Your Reference SSD-77260958
Michelle Niles
Department of Planning, Industry and Environment
Via Major Projects Planning Portal

29 September 2025

**Response to Submission to SSDA
20-24 Railway Parade and No.2-4 Burleigh Street, Burwood
Mixed Use Development**

OSD TANK PLAN  
SCALE 1:50

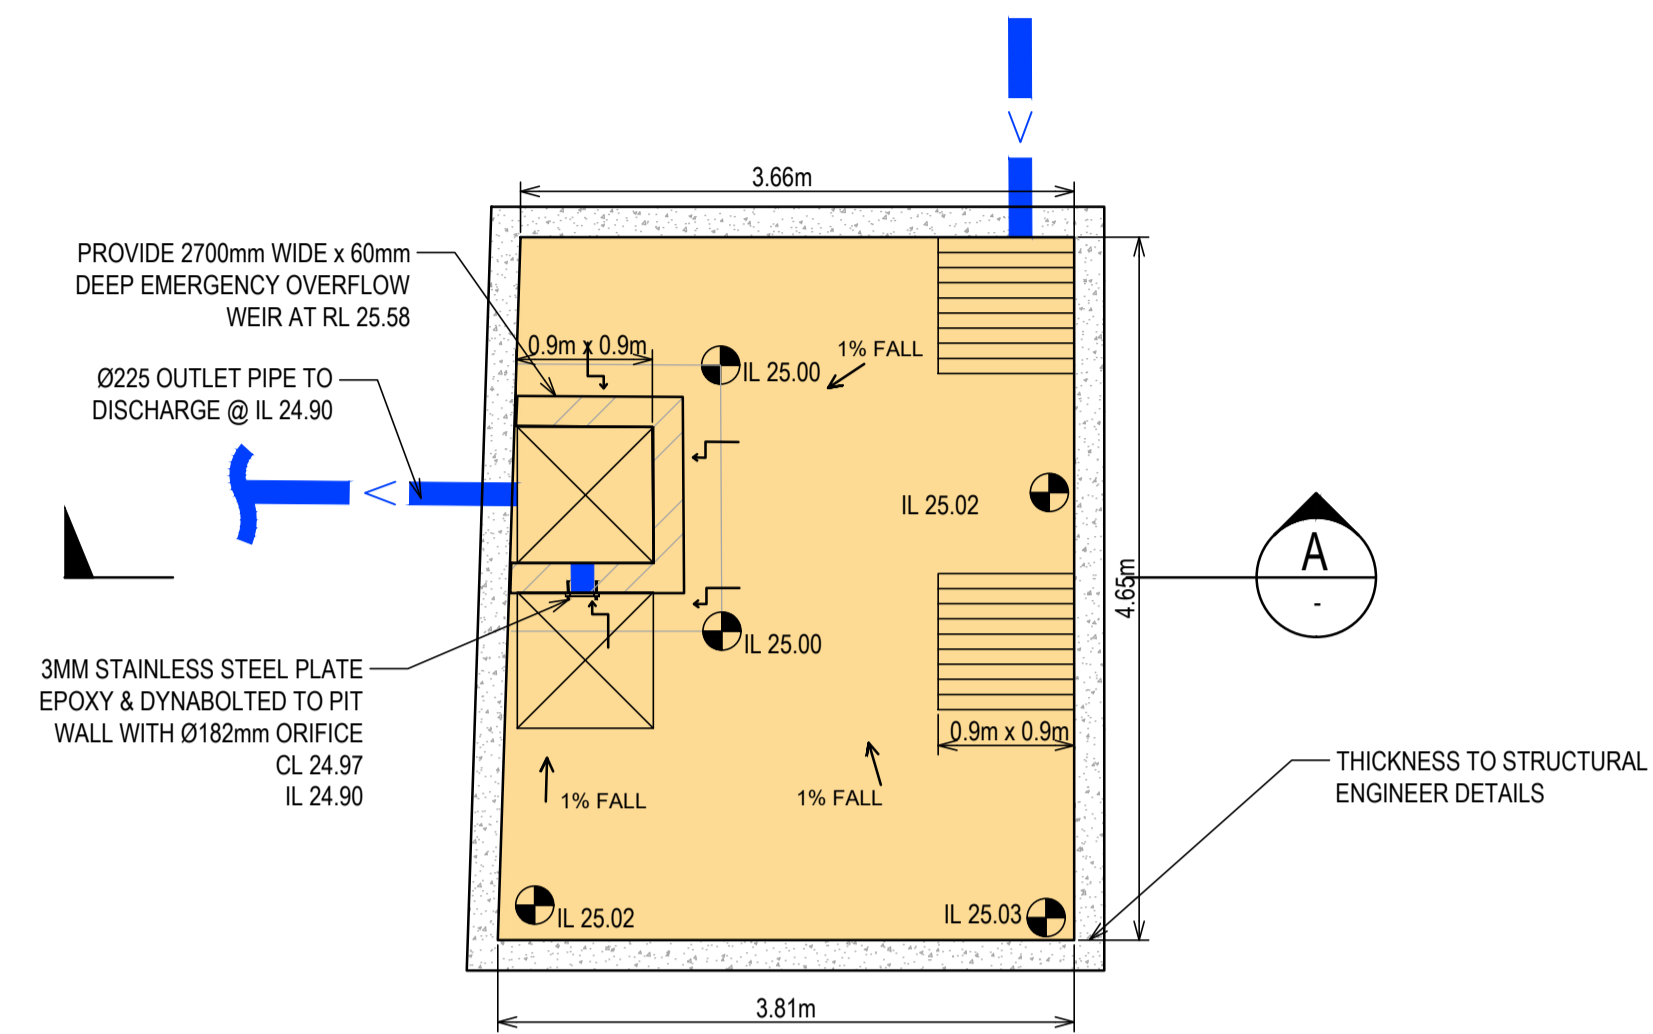
- In accordance with Section 4.7 of Burwood Council Stormwater Management Code, the proposed On-Site Detention (OSD) must restrict out flow from the development site during 100 year ARI storms to a Permissible Site Discharge (PSD) determined from, $PSD (L/s) = \text{Site Area (ha)} \times 150$. The volume of OSD storage shall be determined from, $\text{Vol. (m}^3\text{)} = \text{Site Area (ha)} \times 300$

The ground floor is mixed use comprising of:

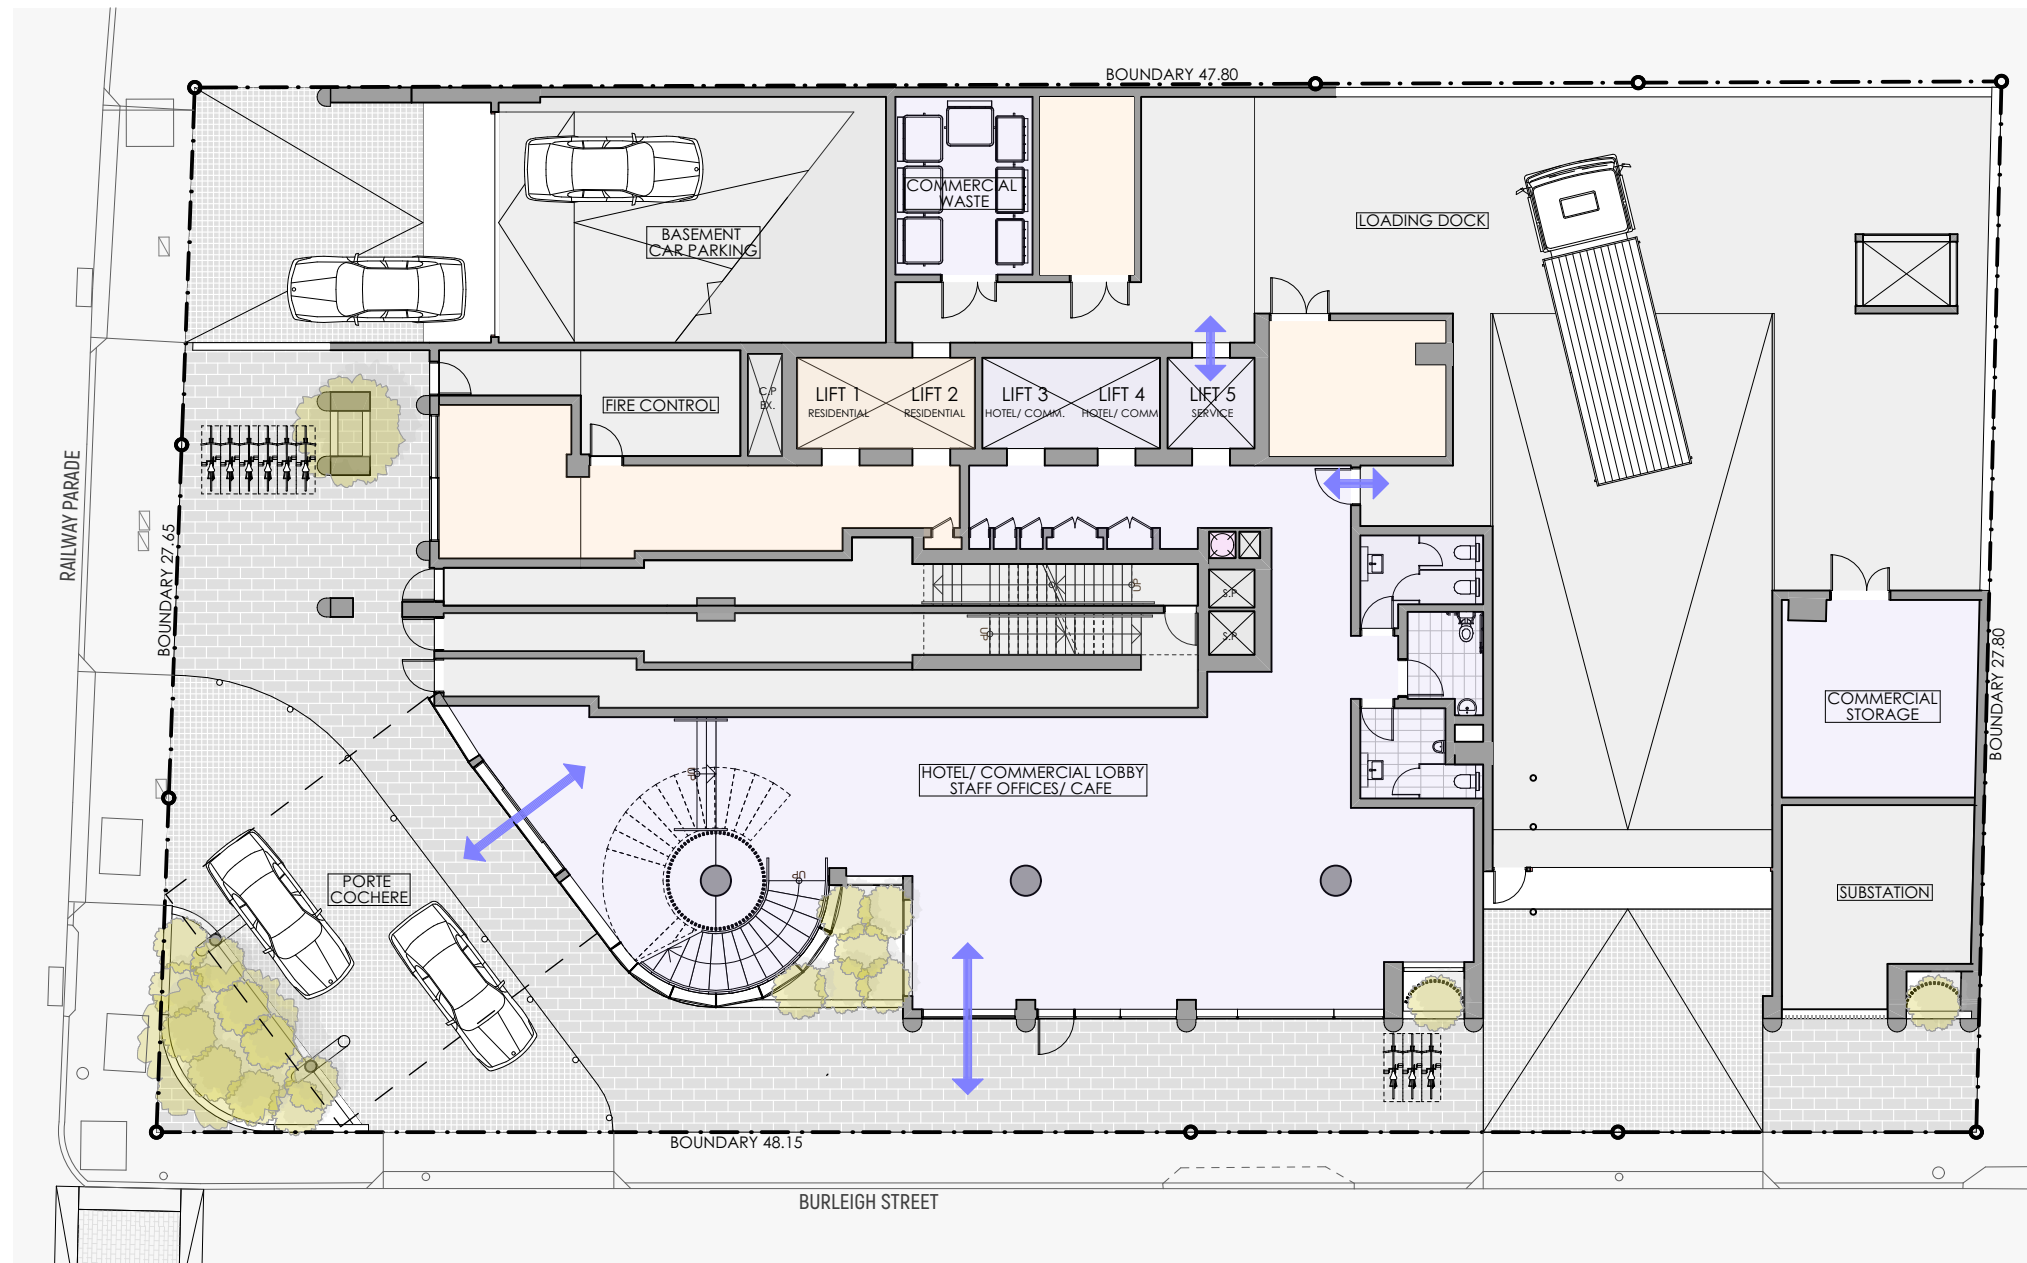
- The proliferation of driveways associated with the proposed development is not supported. It is acknowledged driveway widths have been reduced; however, the extent of driveways remains unchanged to that of the original SSDA proposal.

- Consideration should be given to investigating the consolidation of driveways along Railway Parade, to have a combined single basement car park/porte-cochere. Consolidation of these driveways would improve pedestrian amenity and remove the need to have a driveway located so close to the intersection with Burleigh Street.

- The modification to the Porte-cochere exit shows a reduced driveway width, which pushes exiting vehicles closer to Railway Parade. If the driveway is narrowed it should be required to provide a greater distance from Railway Parade to address the concerns previously raised.

- The modification to the basement driveway which now includes an offset between the vehicle crossover at the kerb and the internal aisle is not supported as it will lead to conflict between entering and exiting traffic.

- No evidence in the way of swept path analysis has been provided for the design of the Porte Cochere to show how two vehicles can use this space simultaneously, or how one vehicle entering can enter if another vehicle is already parked in this space.

- The motorised gate at the entry to the loading dock is to be set back so as to allow the largest sized vehicle to be able to pull into the site fully without blocking the footpath while waiting for the gate to open.

LEVEL 38 RESIDENTIAL COMMUNAL OPEN SPACE

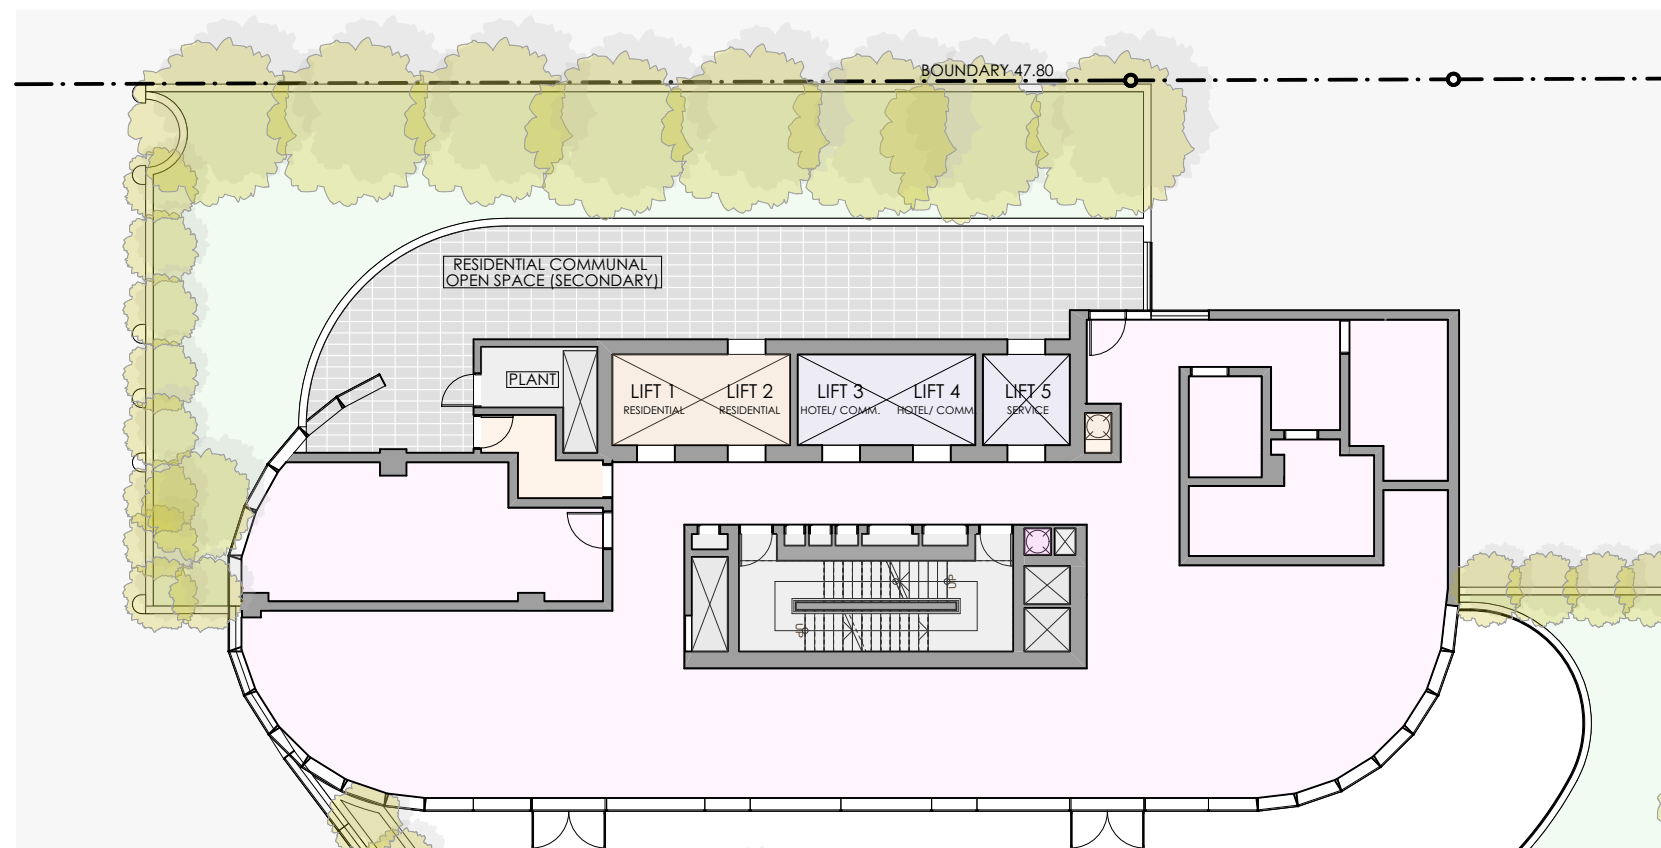
- It is acknowledged that communal open space areas have been provided on Level 2 and Level 38 of the revised architectural floor plans. However, the communal open space areas lack sufficient detail, in terms of plantings and landscaping treatments, balustrades and useability.
- In addition, the Section drawing (Drawing No.27, Revision C) indicates that a large scale air ventilation system is located above the residential communal open space area, whereby their function is unknown. Concerns are raised that these vents may compromise the amenity of the communal open space areas.

LEVELS 3-18 VISUAL PRIVACY & VIEWS

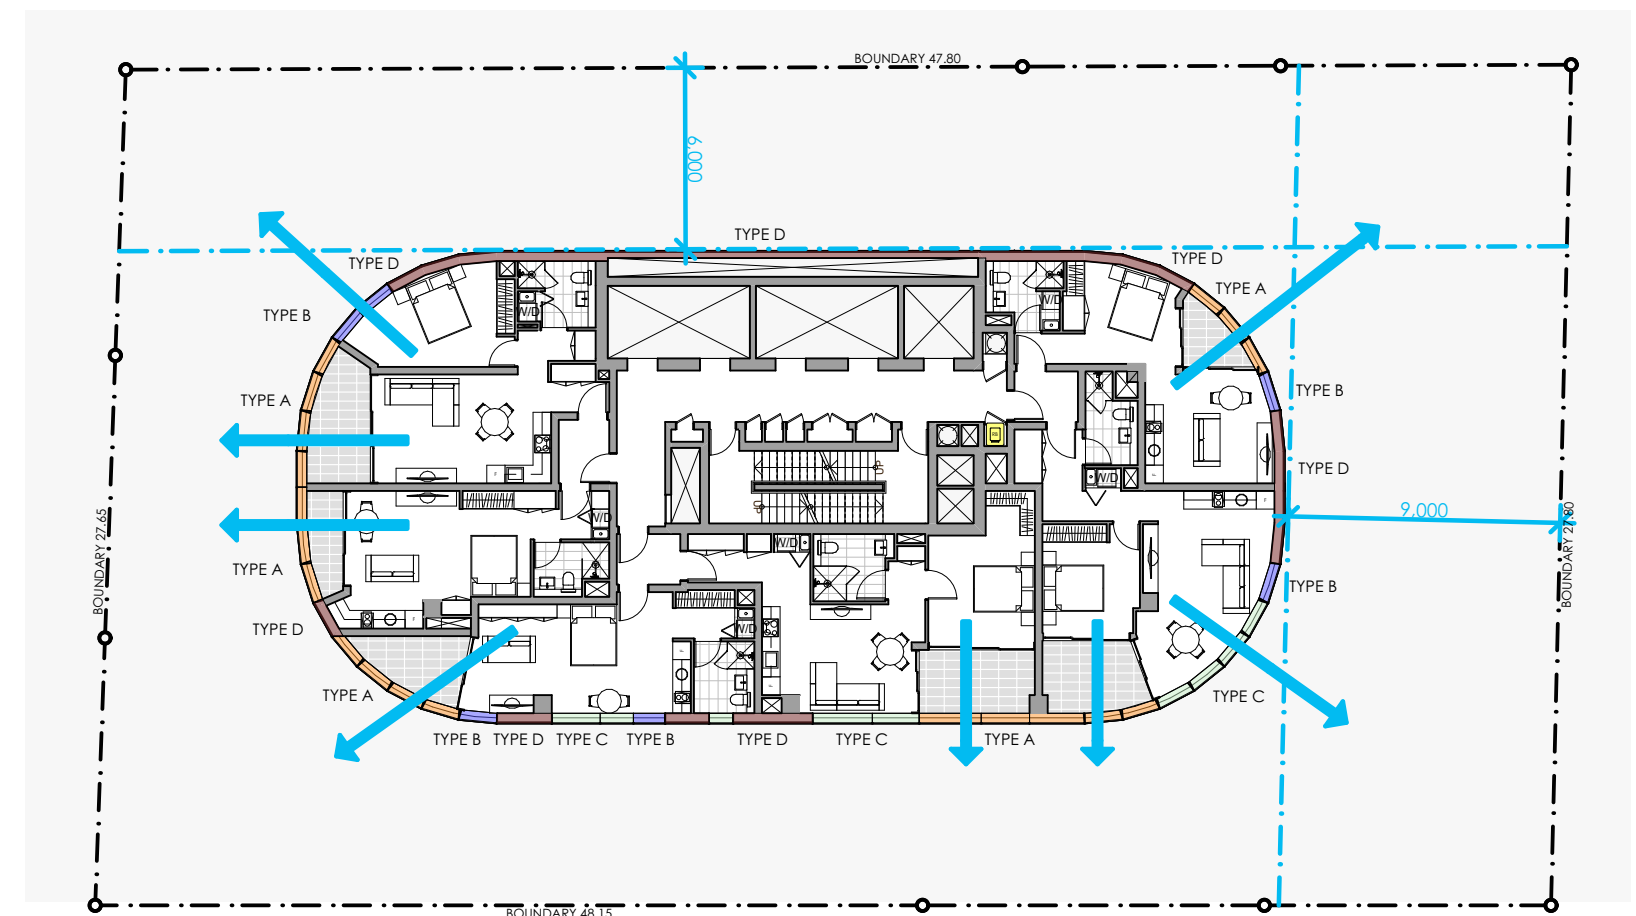
- As indicated in the previous submission response provided by Council. Privacy' glazing is an inappropriate treatment to a constrained site and would limit development potential of adjoining sites.

- The assertion that the rounded corners provide an optimum outlook for the corner apartments, as stated in the submitted response, is inaccurate and misleading. The revised drawings do not address the loss of outlook resulting from the use of opaque glazing on the façade of the bedrooms and lounge in Unit 03B – repeated over 14 levels of the building. Overall, Council has not identified any meaningful design modifications in response to the concerns previously raised.
- The current building separation proposed is 12m to No.18A Burleigh Street, thus failing to comply with the ADG requirements of 24m for 9 storeys and above.

- As indicated in the previous response to submission, opacified glasses which limit the view of the internal spaces are not supported as a solution to compensate for insufficient separation distances.

BASEMENTS 3-5- RESIDENTIAL CAR PARKING

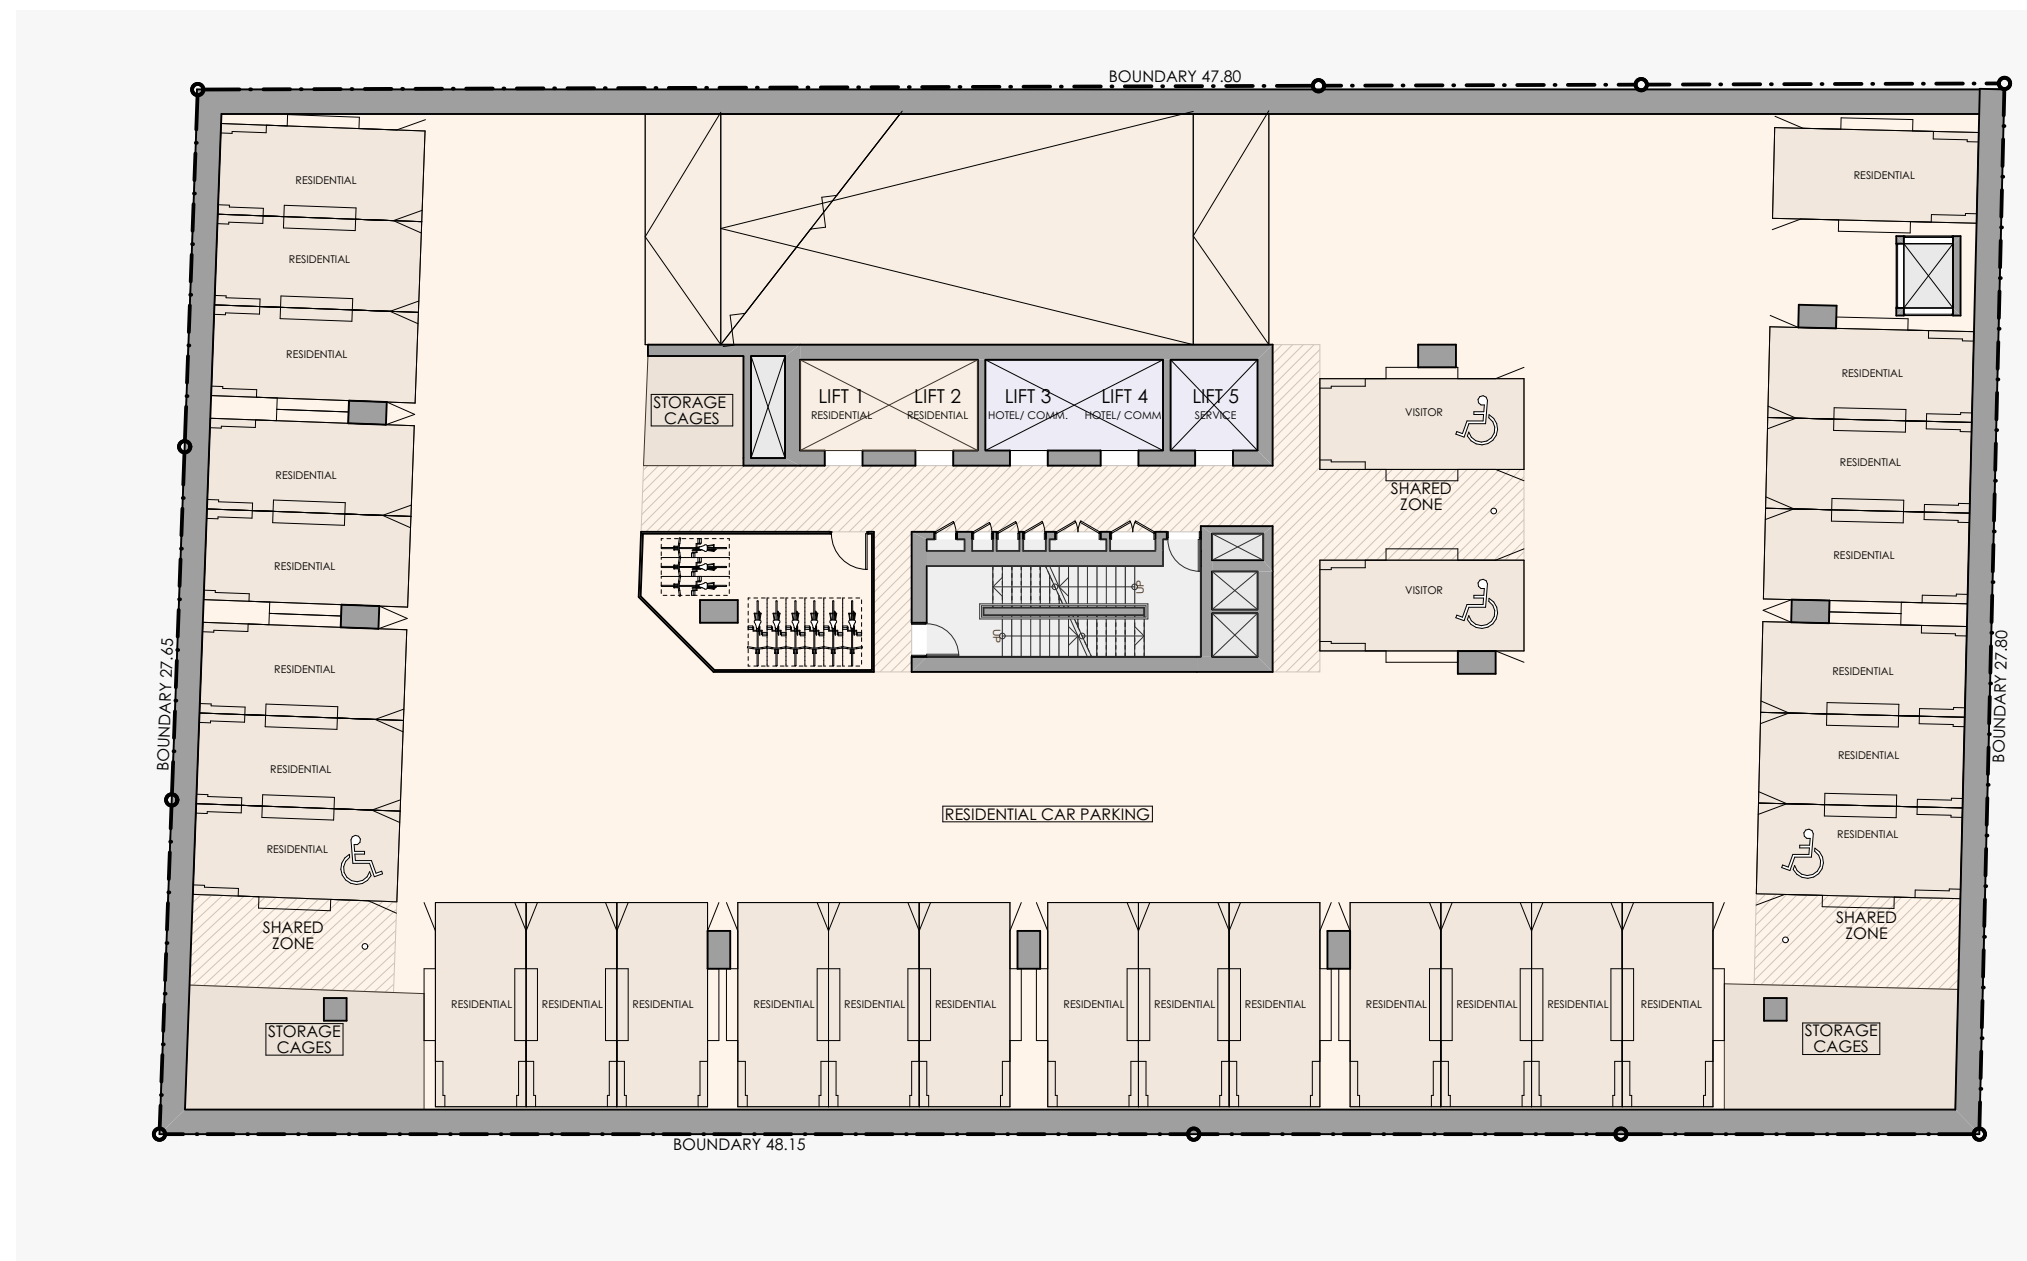
- The motorised gate on the ramp on level B2 which leads down to level B3 will restrict access to resident visitor parking spaces. All resident visitor parking spaces are therefore required to be placed on level B1 and accessible at all times, or alternately able to be accessed via an intercom to all residential units. A turning space would be required to be provided on level B2 if visitor spaces are to be located on level B3 in the event that a visitor cannot get access to B3.
